RESPONSE TO DP&E REQUEST FOR ADDITIONAL INFORMATION - MOD 1 TO MP09_0146 EASTLAKES SHOPPING CENTRE

This letter has been prepared by Urbis on behalf of Stateland East Unit Trust (The Applicant) regarding MP09_0146 Mod 1 – Modification to Eastlakes Shopping Centre Mixed Use Development.

2 EASTERN LANEWAY BOUNDARY WALL
1 : 20

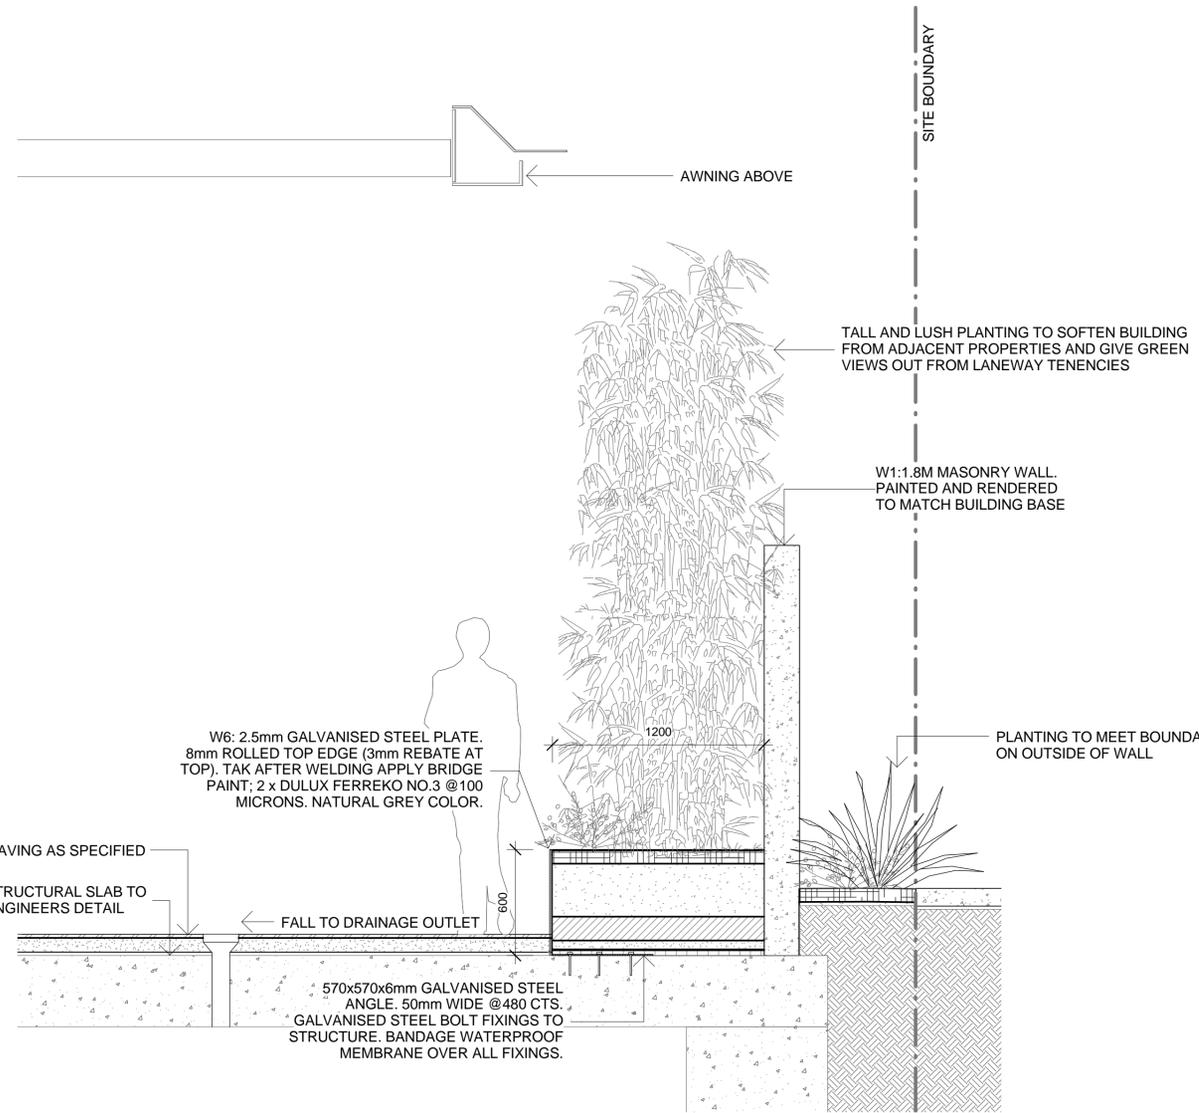
1. *The proposed landscape plans significantly reduce the width of the landscaped setbacks and the extent of plantings, along both boundaries at the ground and podium levels. These changes, including conversion of areas from landscaping to egress/access paths on both sides, are not supported as they would impact on the amenity of adjoining properties. This was a key issue in the assessment of the original application and is contrary to the intentions of modifications B2 and B5.*

In response to DP&E comments, a landscape strip has been incorporated into the revised proposal. This landscaping sits on either side of a 1.8m high masonry wall which is proposed close to the boundary in order to ameliorate noise and privacy impacts to the neighbouring residents. This wall adjoins the neighbouring building's vehicular driveway, with the neighbouring building setback further to the east with limited window openings and open space areas along the western elevation at ground level. This means it will have limited visual impacts on the neighbouring property.

Given the above, the proposed secondary pedestrian entry is considered acceptable. As illustrated in **Figure 3**, the landscaped strip comprises suitable species to soften the wall's appearance and give green views out when viewed from the driveway, generally consistent with the approval.

Drawing title
SOIL DEPTH PLAN

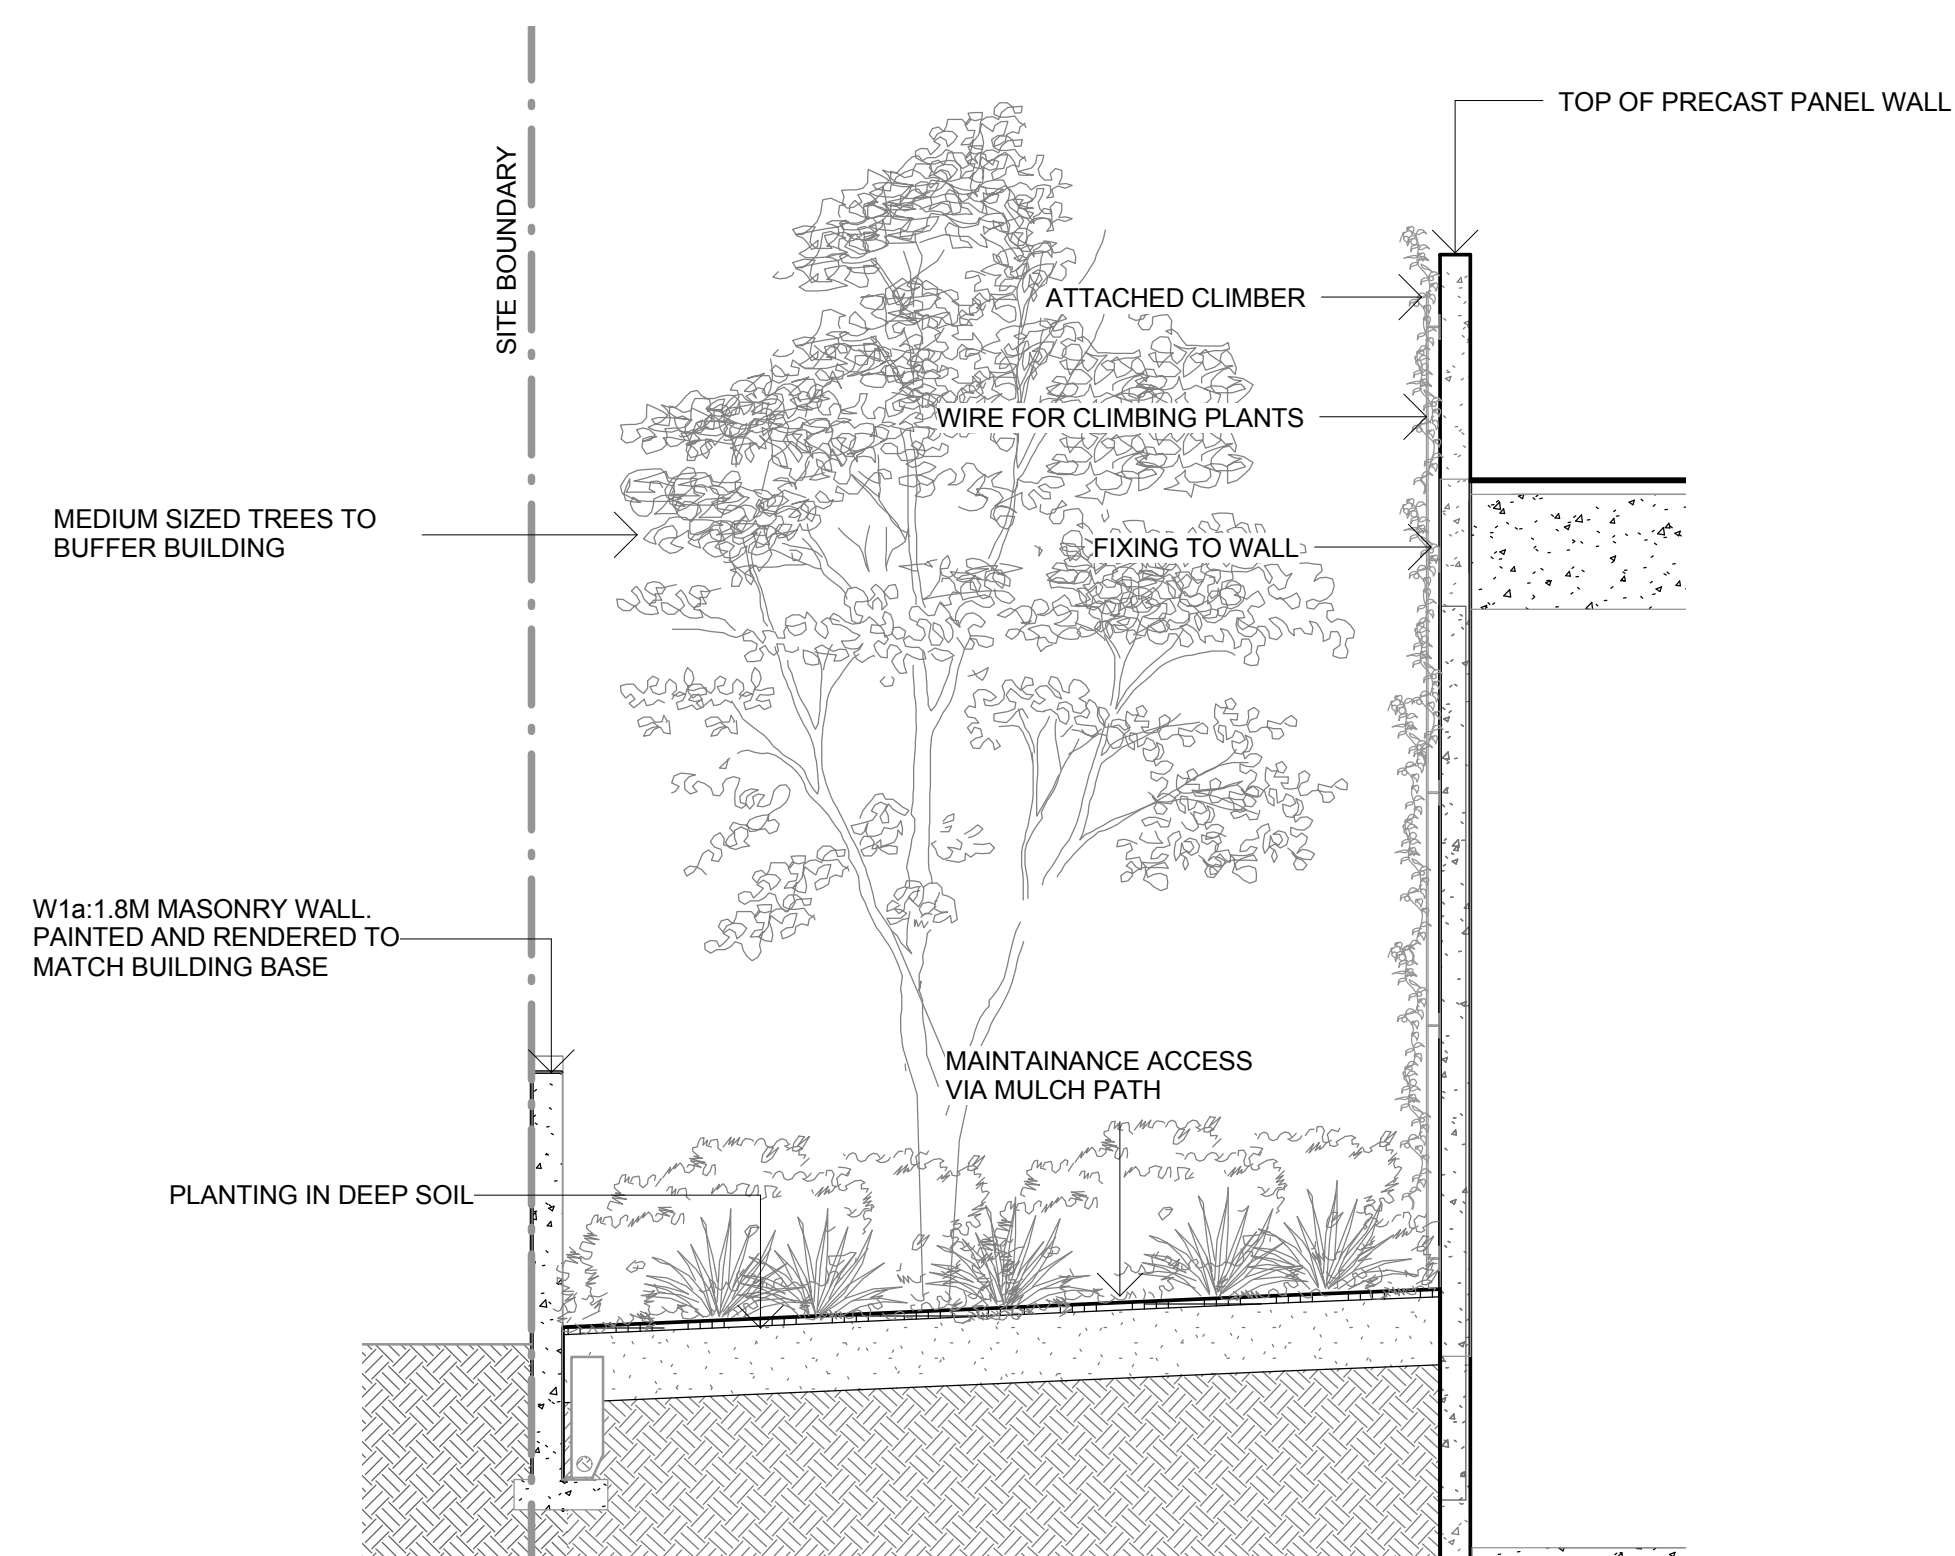
6. *The Landscape plan does not provide sufficient information. The approved landscape plans include specific planting details, species, soil depths. An updated plan to the same level of detail should be provided. The extent of landscape planting, particularly the provision of trees across the site should not be reduced and ideally should address the requirements to improve the extent of planting as required by conditions B3 – B5.*

Additional landscape improvements compared to the submitted proposal at ground floor and podium level along the eastern and western boundaries have now been incorporated (see **Appendix A** and **B**). The proposal results in 1,511m² of planting area which is 260m² greater than the approved design.

Additional landscape plans have been prepared and are submitted at **Appendix B**. The level of detail is consistent with the approved plan set including ground floor and podium landscape plan, planting plan, soil depth plan, sections, typical details and material schedule.
